A1 Birtley to Coal House Scheme Number: TR010031

Allerdene Burn – Channel Design Concept

**Allerdene Burn – Channel
Design Concept**

Version	Date	Status of Version
Rev 0	09 June 2020	For Issue

**STRUCTURES ENGINEERING DRAWINGS & SECTIONS REGULATION 5(2)(o)
ALLERDENE BRIDGE (EMBANKMENT OPTION)
(SHEET 3 OF 14)**

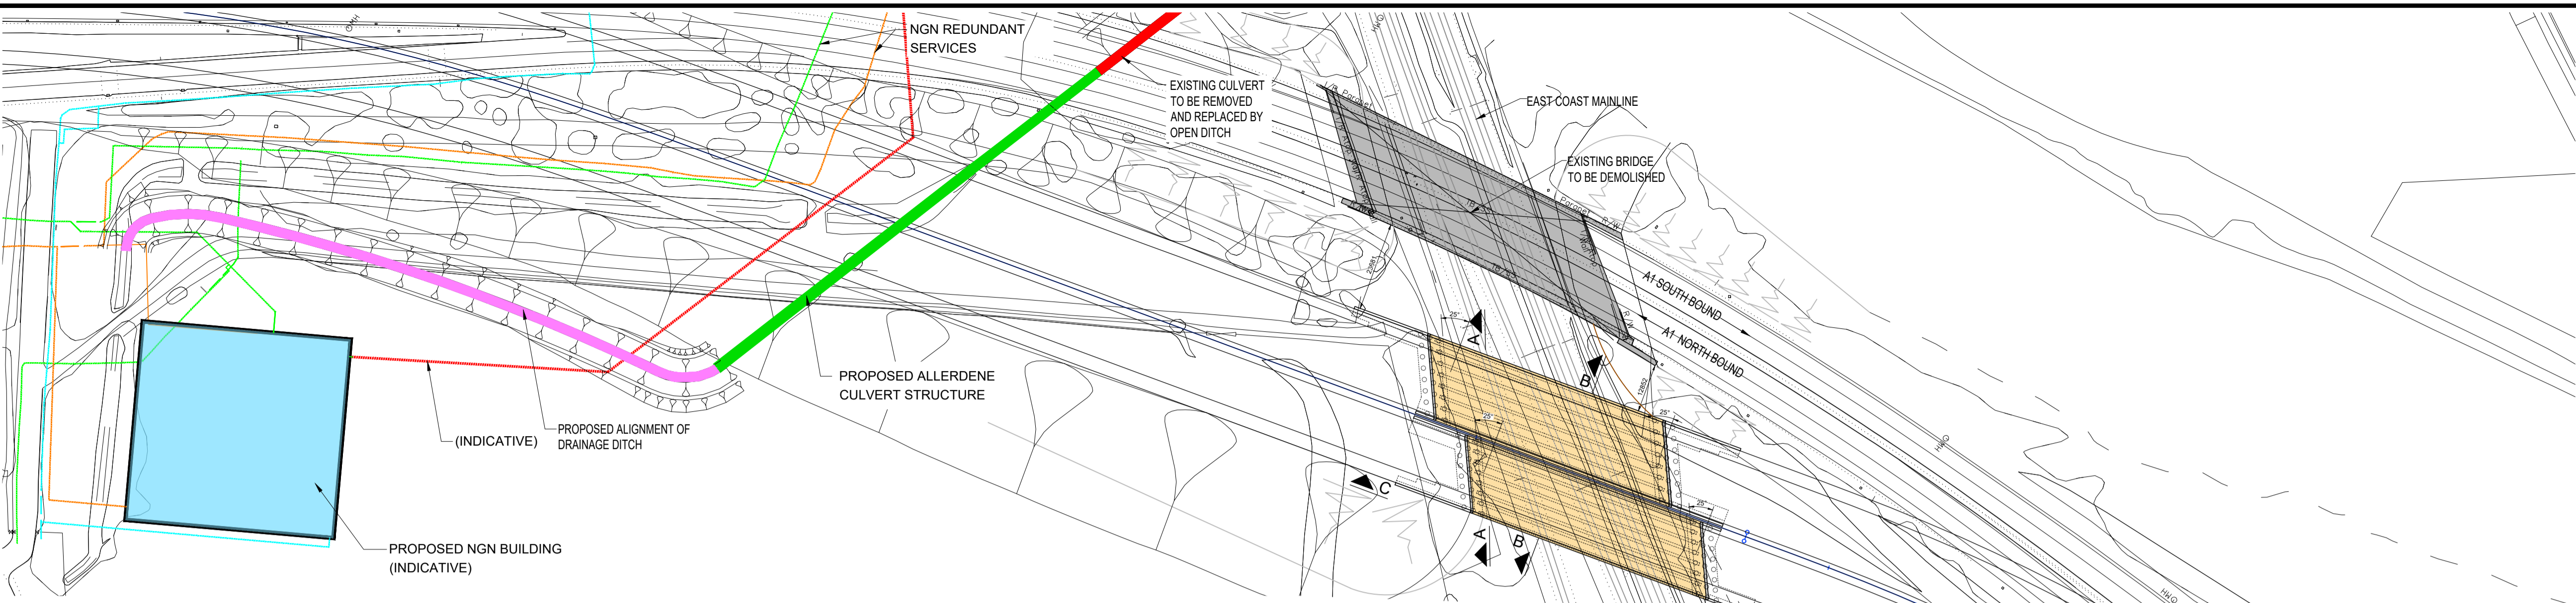
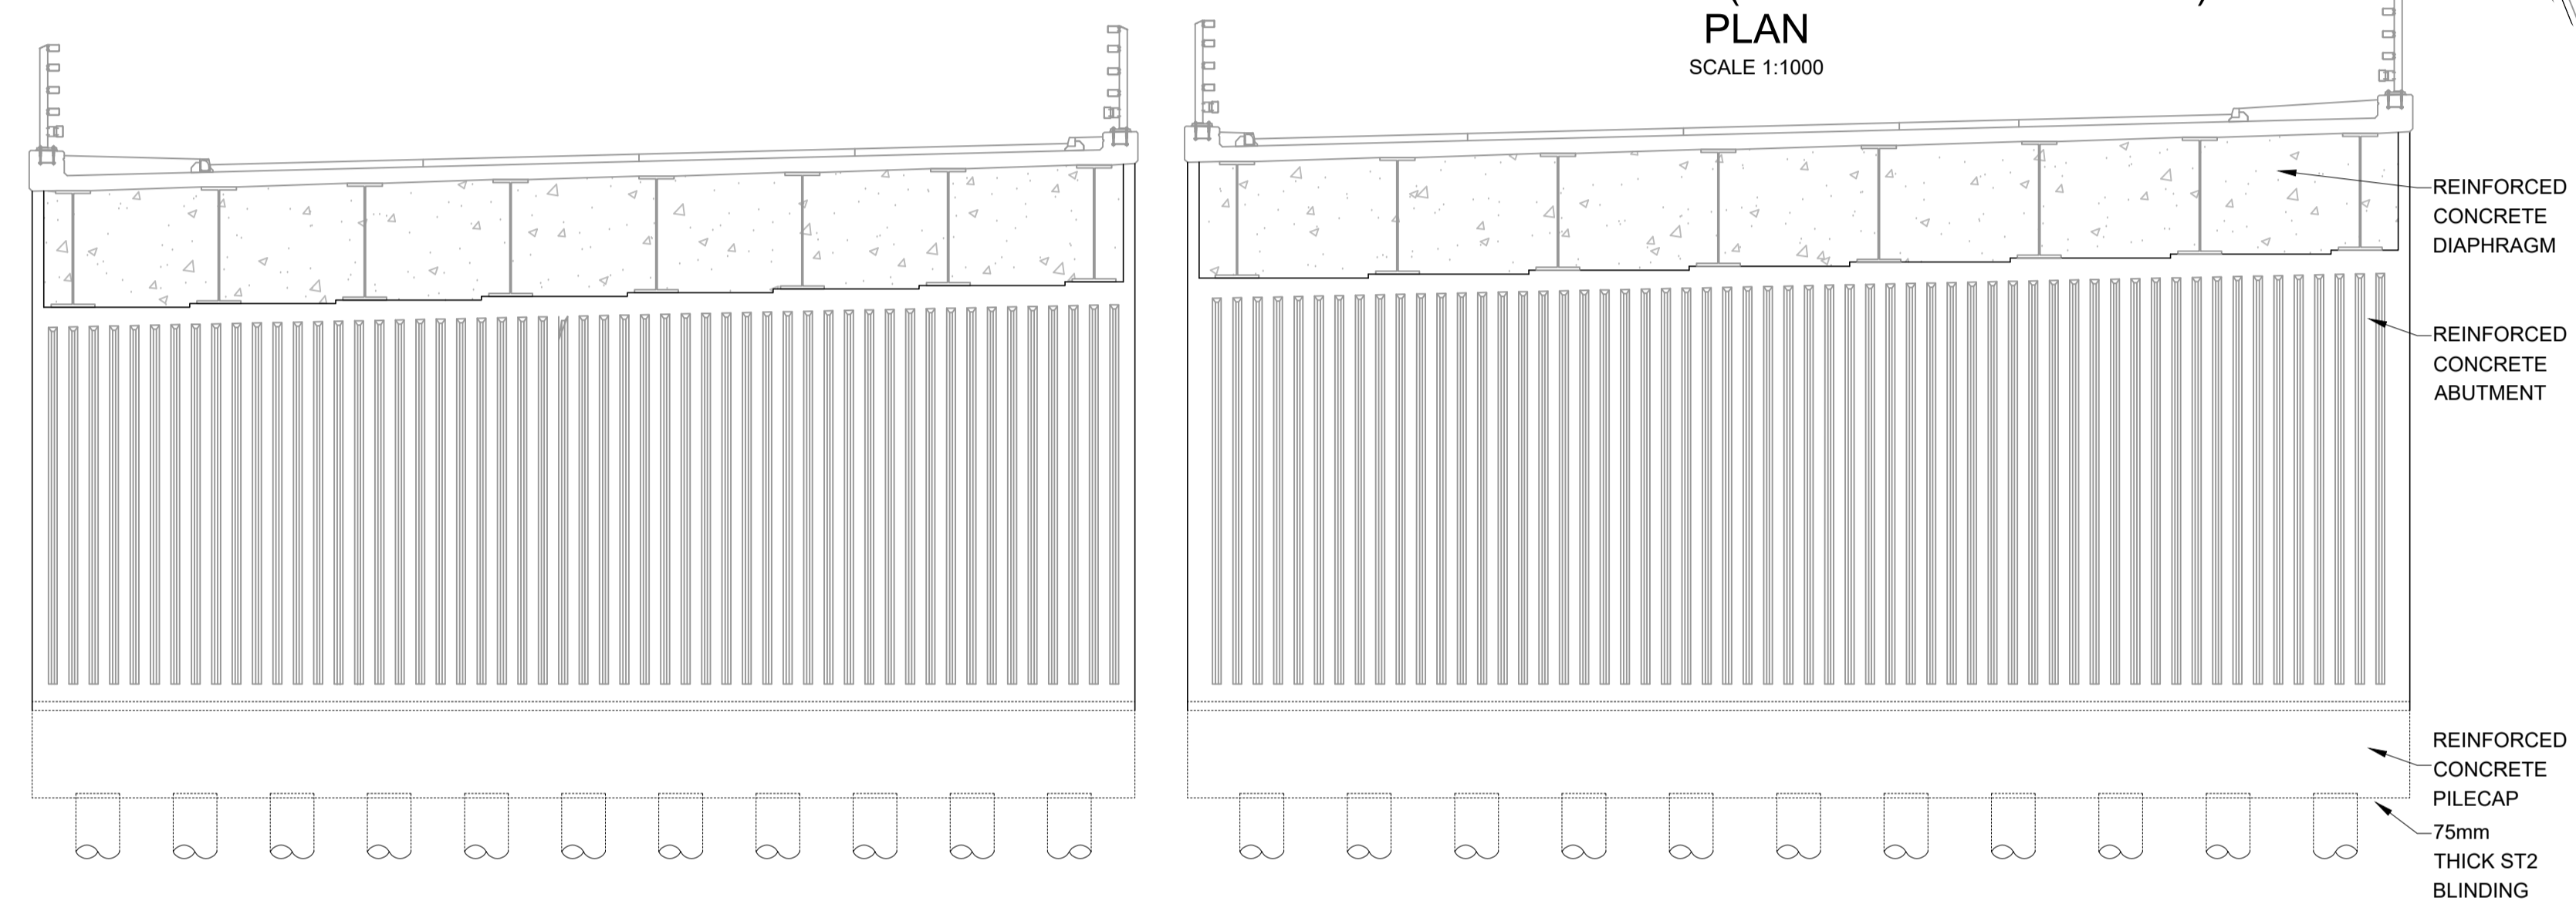
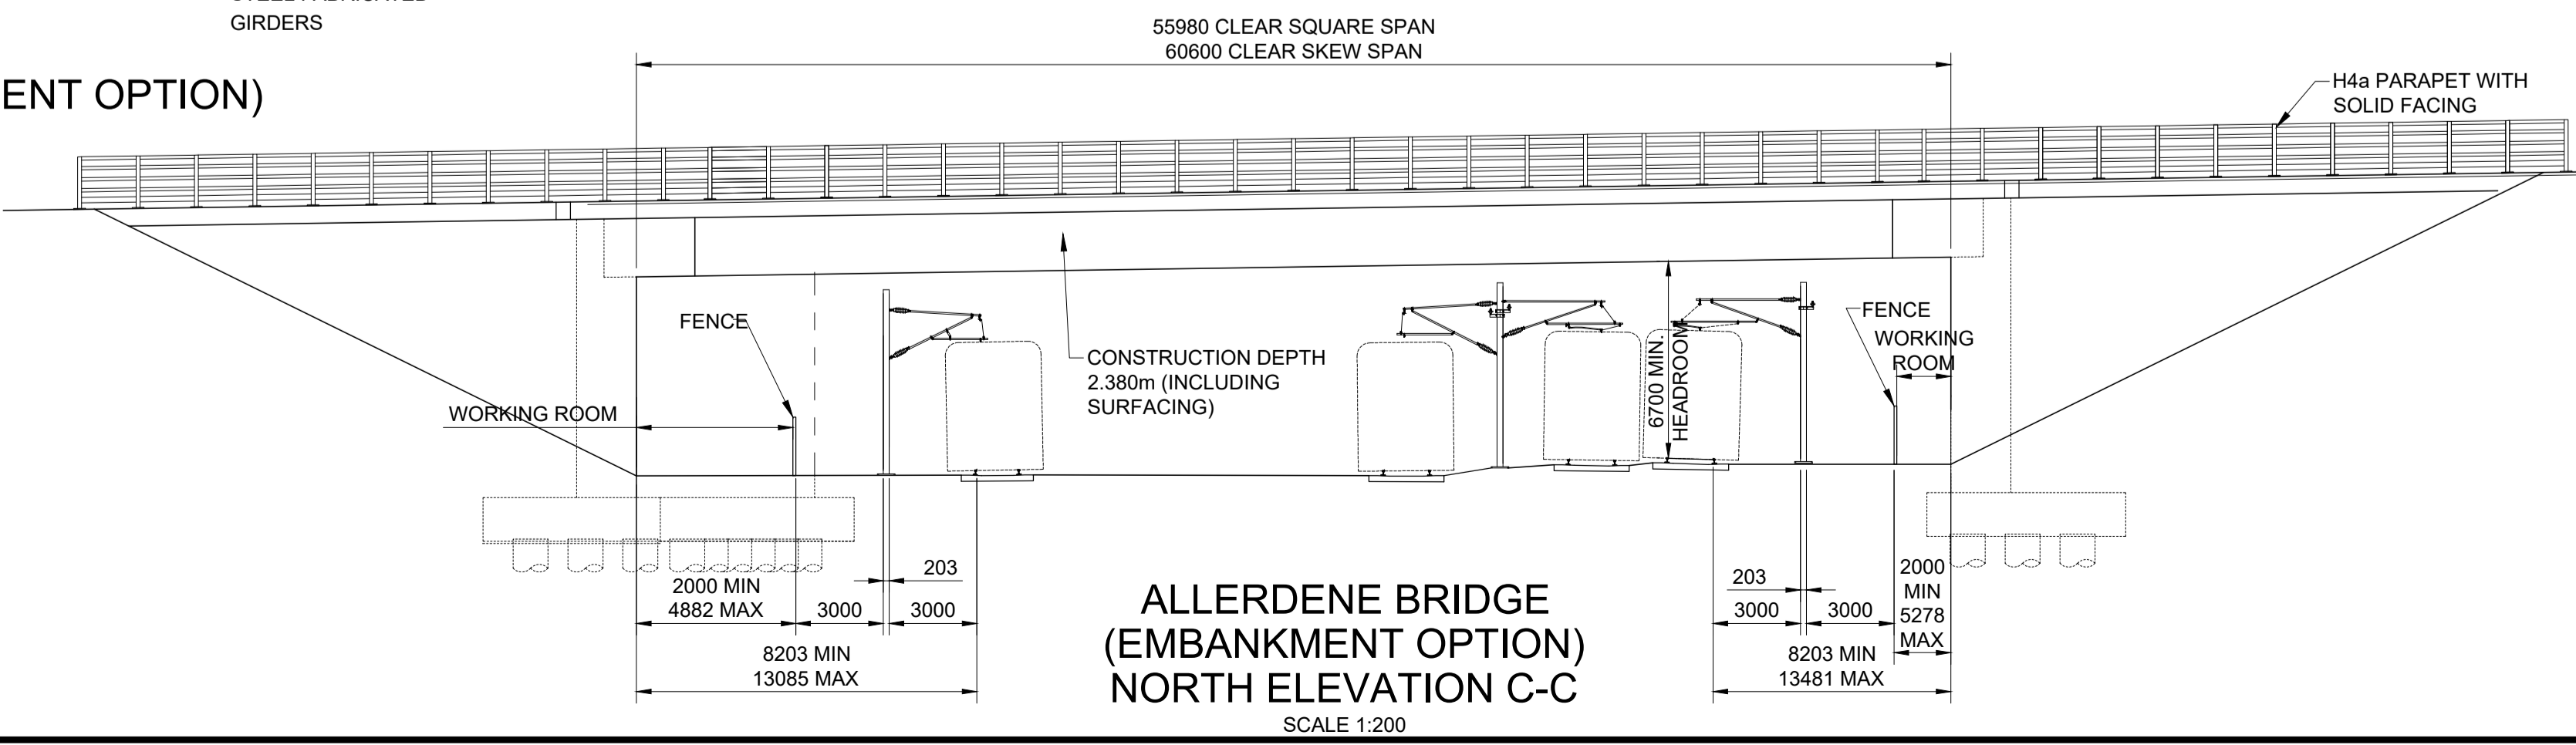
***Allerdene Burn:** The re-aligned and opened-up sections of the Allerdene Burn shown on the General Arrangement drawings (all 3 options) are over-engineered, with not enough variation in form or profile. It goes against good flood risk management principles with an engineered design and disconnect from its floodplain. The drawings should be modified to show a more naturalised channel that would conform with paragraph 5.2.3 of the WFD Assessment (Appendix 13.2). There is space to incorporate some areas of widened channel with slackened bank profiles, pools, and possibly some connected floodplain areas. Although the Environmental Statement suggests that naturalised features could be considered at detail design stage, a firm commitment to them should be made now, to avoid them being overlooked or value-engineered out at detail design stage.”*

- 1.1.4. This assessment provides the conceptual design of the naturalisation of the Allerdene Burn through the following aspects:
- A review of the baseline conditions
 - Provision of the concept channel design (both plan and long sections)
 - Assessment of the design
